**WEST SUSSEX COUNTY COUNCIL
STRATEGIC PLANNING CONSULTATION**

SUBJECT: LU/381/14/HH - Proposed dropped kerb. This application may be determined by Littlehampton Town Council under delegated powers.

70, Southfields Road, Littlehampton, BN17 6PB

Block Plan shows area bounded by: 504007.27148438,102344.30273438 504097.27148438,102434.30273438 (at a scale of 1:500) The representation of a road, track or path is no evidence of a right of way. The representation of features as lines is no evidence of a property boundary.

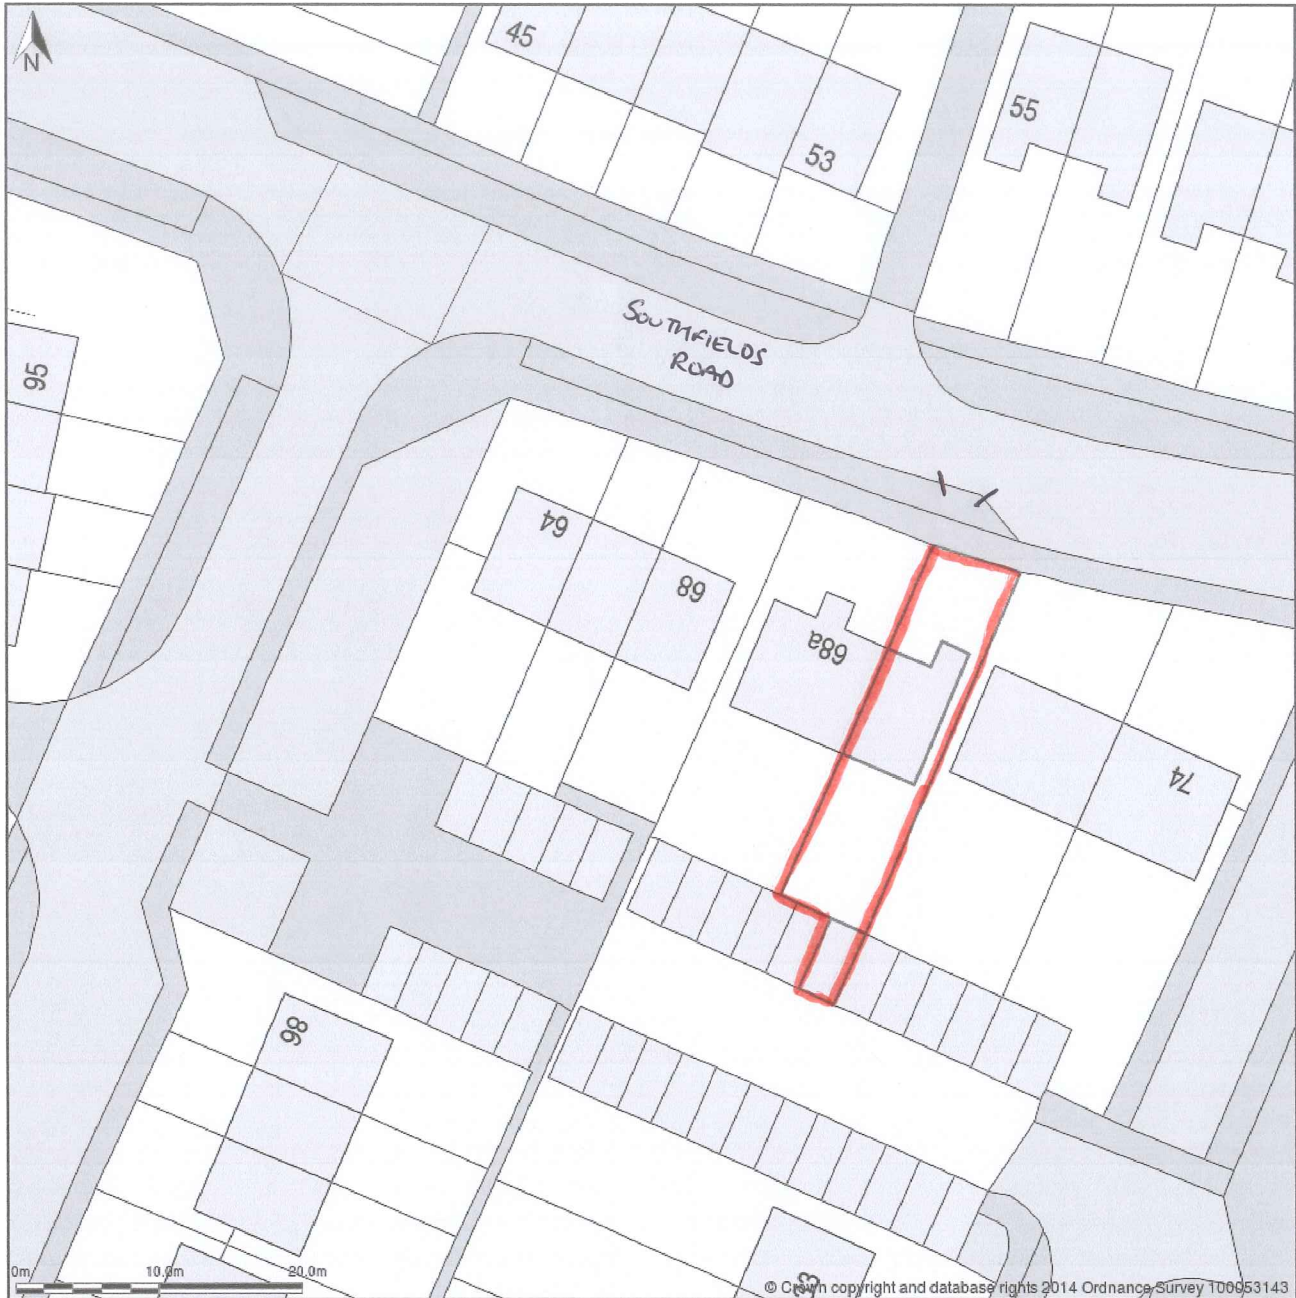
It is noted that the crossover will be construed on the western extent of the property frontage. The crossover should not therefore interfere with the existing layby or the existing street lighting column. It is observed that there are two white bollards within the highway boundary in this location, these are obstructing land considered to be publically maintained highway and should be removed.

The crossover must be constructed under licence to a specification obtained from WSCC Highways. No details have been provided pertaining to any proposed hard standing area for vehicle parking. This area must measure 2.4 x 4.8 metres and be constructed in a bound material. I would ask these details are secured via condition.
